DOC18/621722/-01  
SSD 7665

**SSD 7665 MOD 1 – JOAN SUTHERLAND THEATRE**

The EPA is concerned that the Statement of Environmental Effects (SEE) does not appear to fully address potential environmental impacts, especially noise impacts, runoff from excavation and construction works adjacent to Sydney Harbour, and dust control and management.

Figure 1: Indicative thrust block construction source locations

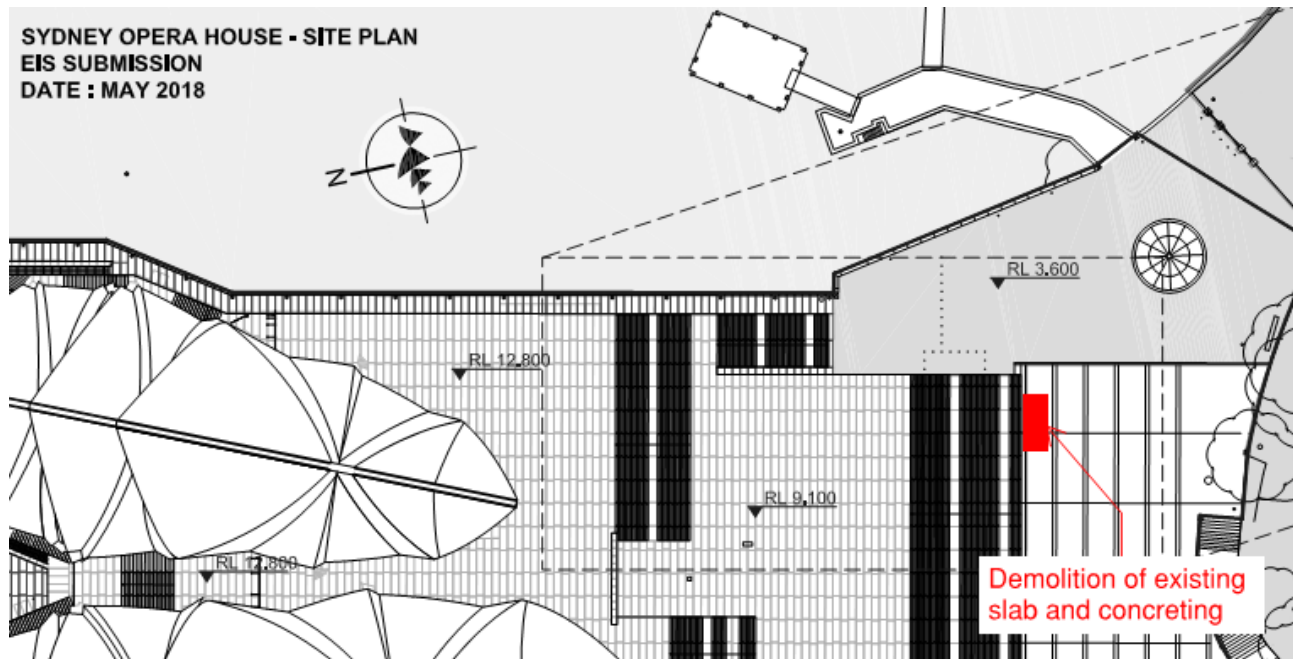
For instance, Table 3 to SEE Appendix 06 'Noise Impact Assessment' refers to proposed construction activities that do not appear to include high noise impact works identified in SEE section 5.1, being –

- (a) rock hammering to excavate the 9 metre by 6 metre by 3 metre deep thrust block trench, or
- (b) concrete sawing of the re-inforced concrete north-south tie beams (the cutting of which necessitates the installation of the thrust block).
